**CITY OF ALBUQUERQUE
PLANNING DEPARTMENT
April 25, 2012
DRB Comments**

PROJECT # 1009239

APPLICATION # 12-70122

RE: Lot 12-A, Block 5, J.W. Van Cleave Homestead Addn.

PLAT OF
LOTS 12-A-1 & 12-A-2, BLOCK 5
J.W. VAN CLEAVE HOMESTEAD ADDITION
SECTION 29, T10N, R4E N.M.P.M.
CITY OF ALBUQUERQUE
BERNALILLO COUNTY, NEW MEXICO
APRIL 2012
SHEET 2 OF 2

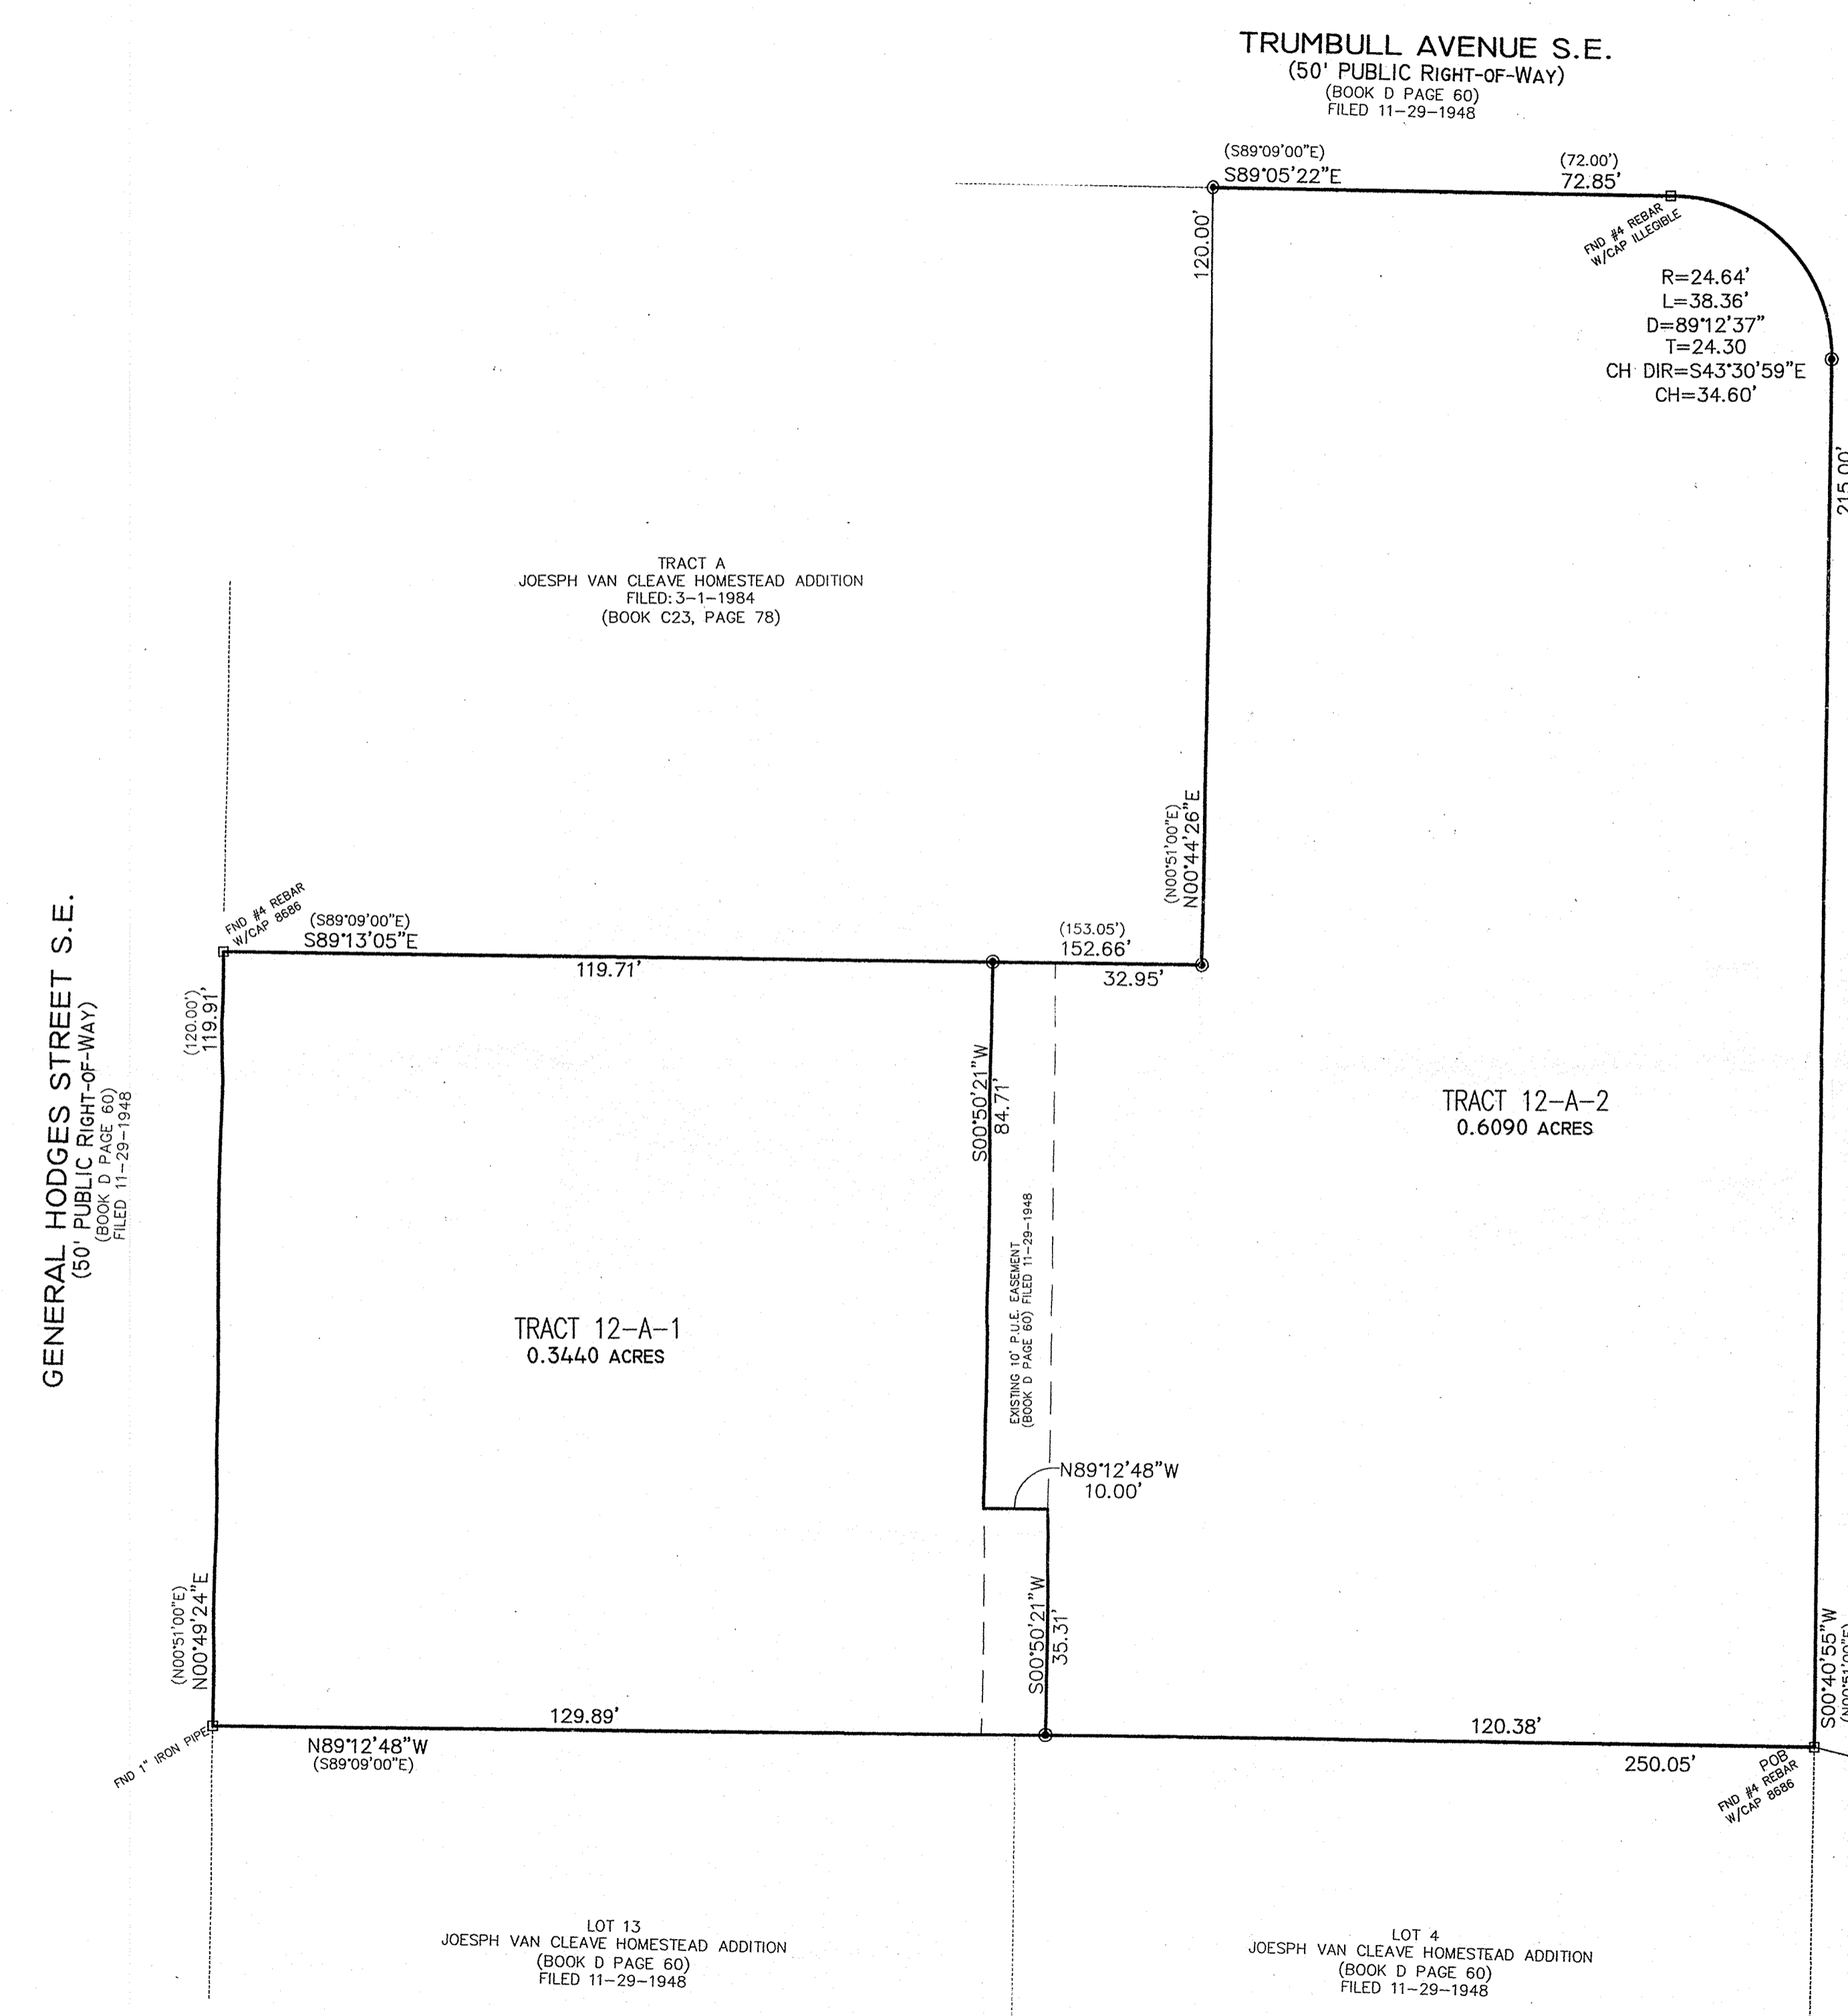
Additionally, a licensed engineer or architect must verify that the buildings meet the code requirements based on proposed lot lines (10 foot setback and zero setback).

SITE SKETCH
LOT 12-A-1 & 12-A-2
J.W. VAN CLEAVE HOMESTEAD ADDITION
LOT 12-A, BLOCK 5
CITY OF ALBUQUERQUE

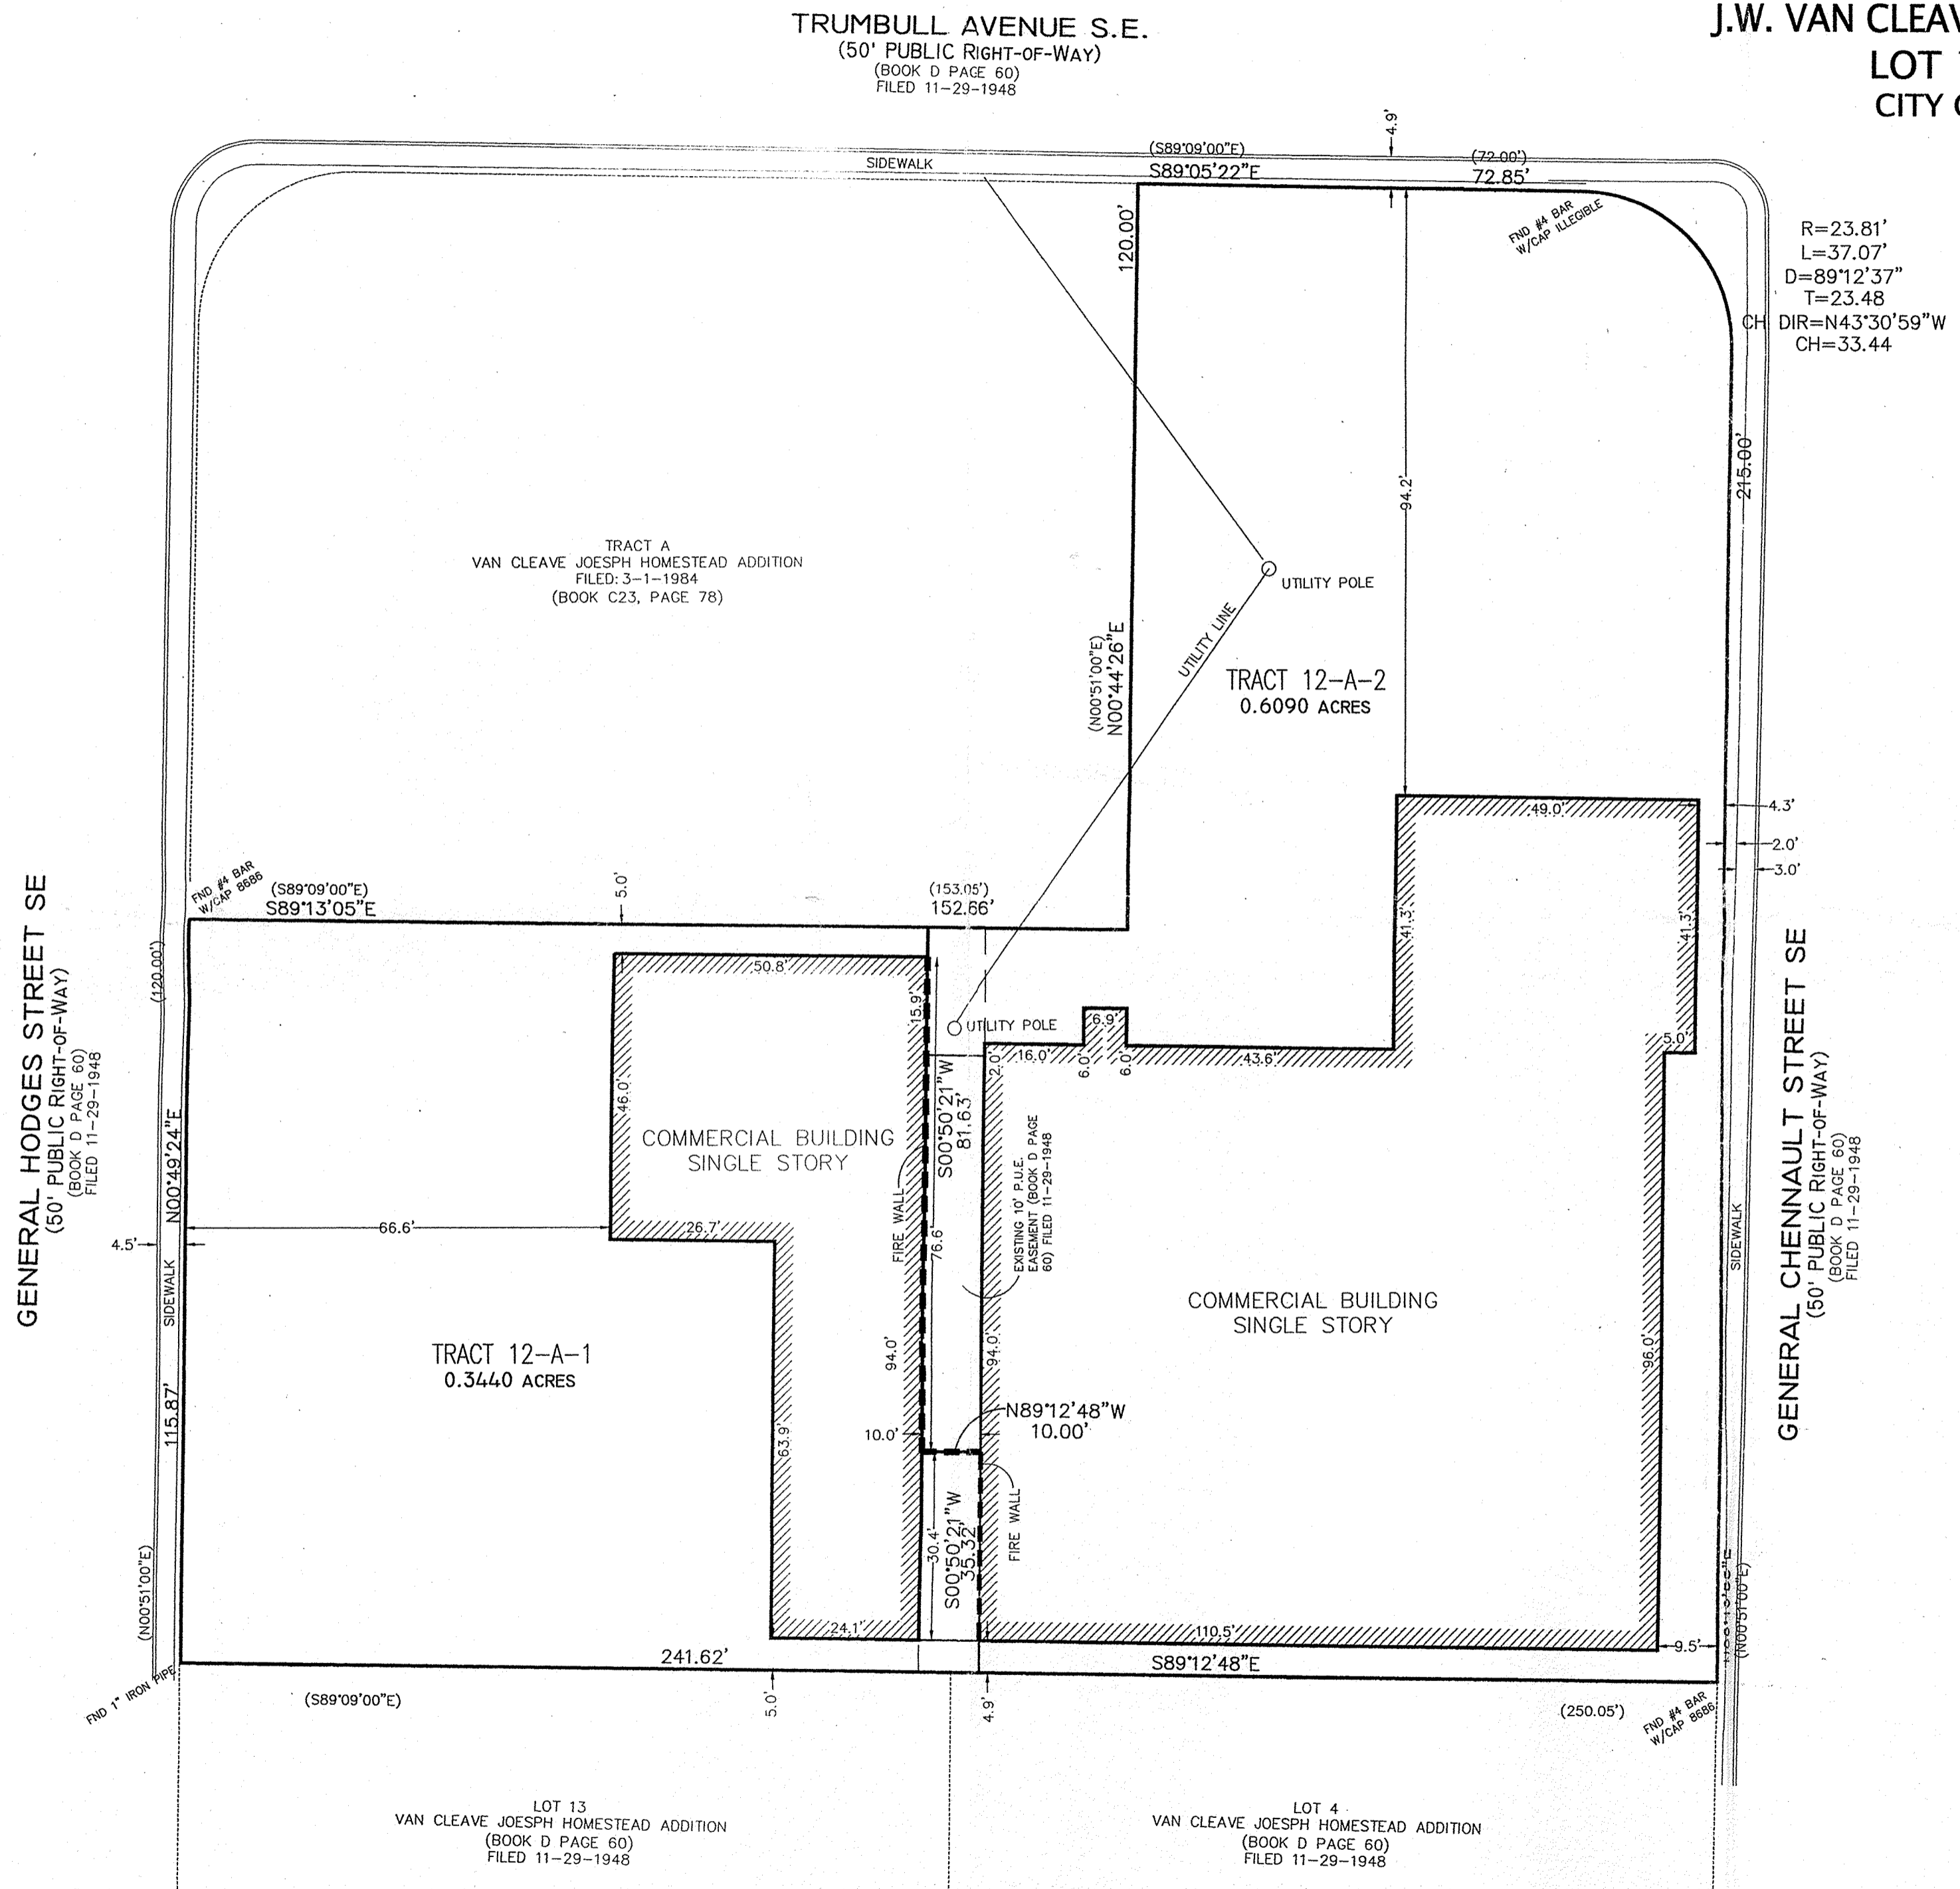
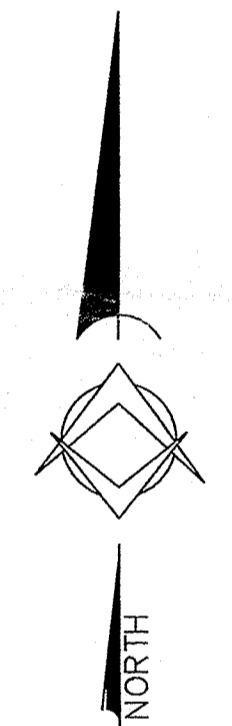
Each proposed lot must demonstrate that Zoning Code parking requirements are met on on-site (on the lot), or a Parking Variance would have to be approved prior to platting.
